Planning Application AW/360/14/HH
91 The Fairway, Aldwick Bay Estate, Bognor Regis.

We enclose 4 copies of drawing 9B as substitute for 9A originally submitted, will you please accept this for the application.

DEC 2014
REQ 9XB.

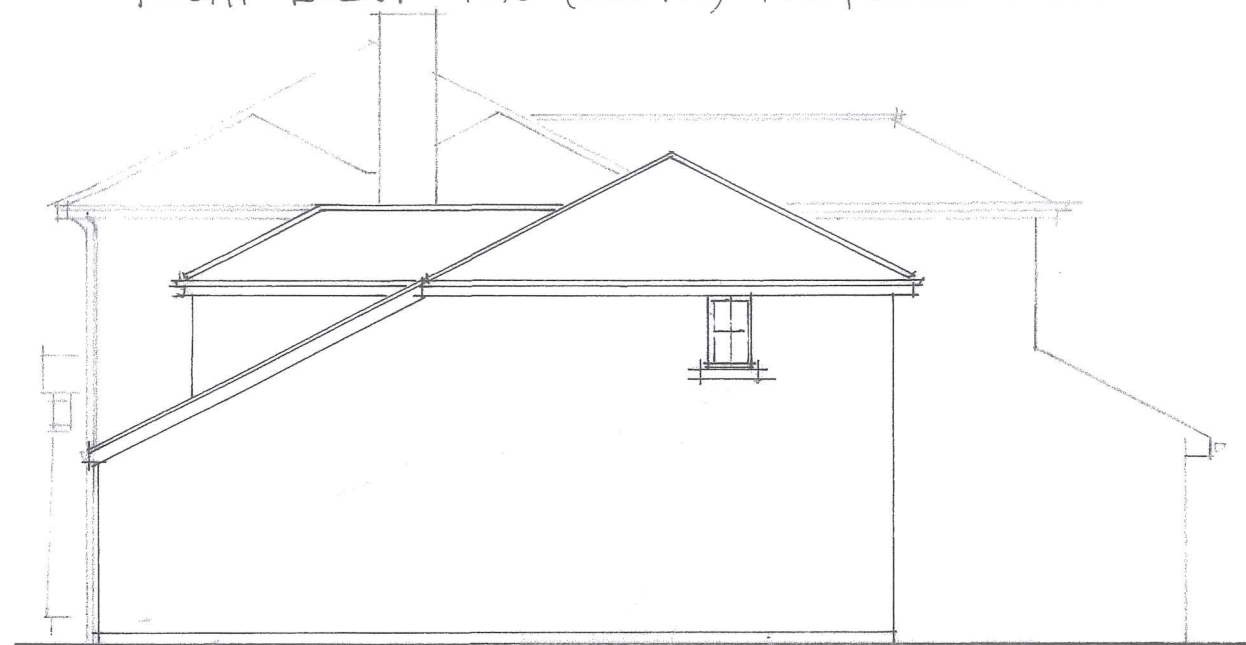
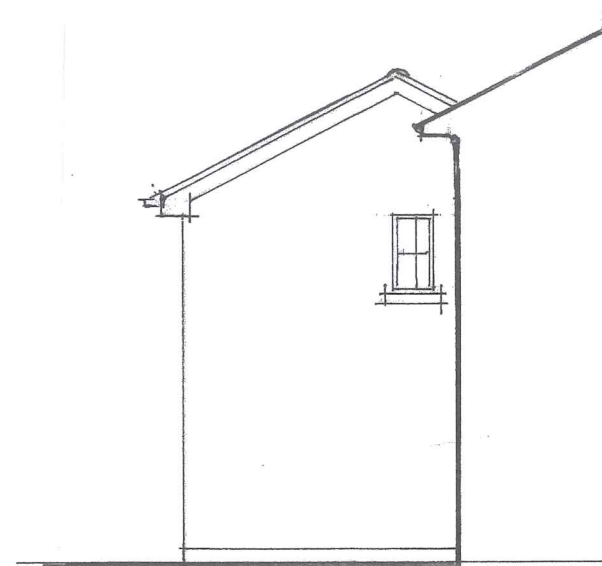
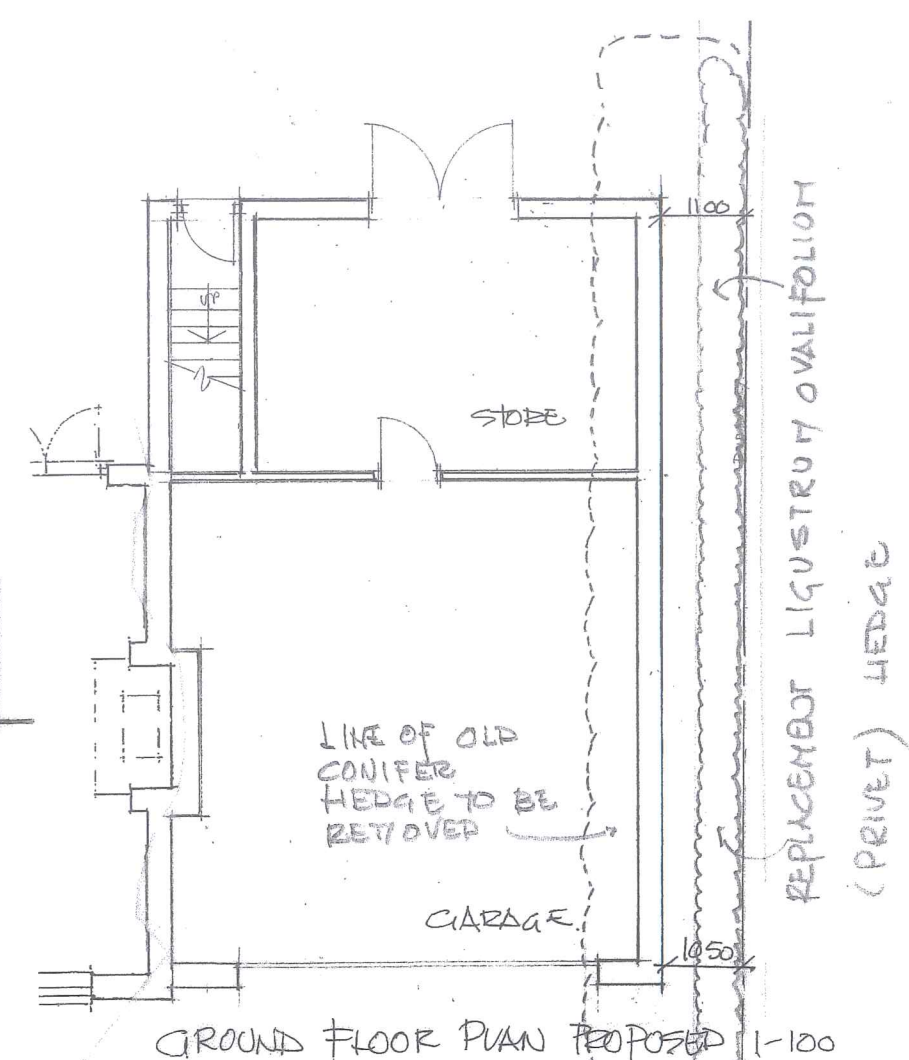
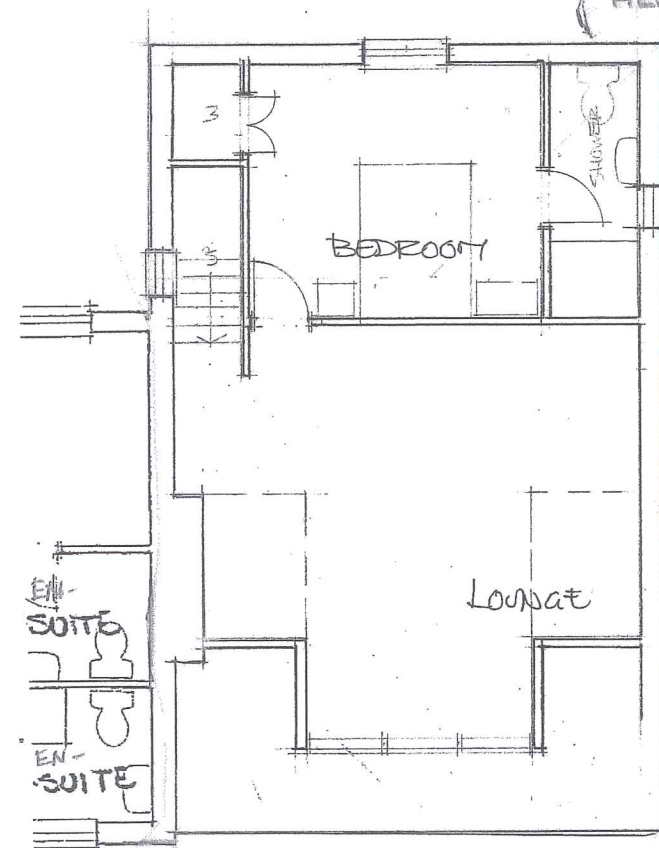
The proposal is to remove the old overgrown conifer hedge from the area of the extension. This hedge is far too large for the location and in poor condition. The roots will be grubbed out and the soil prepared for a replacement hedge.

A replacement hedge of *Ligustrum ovaliflorum* (privet) is proposed, 450 stock plants at 300 centres in well composted soil and well mulched. This is indicated on drawing 9B.
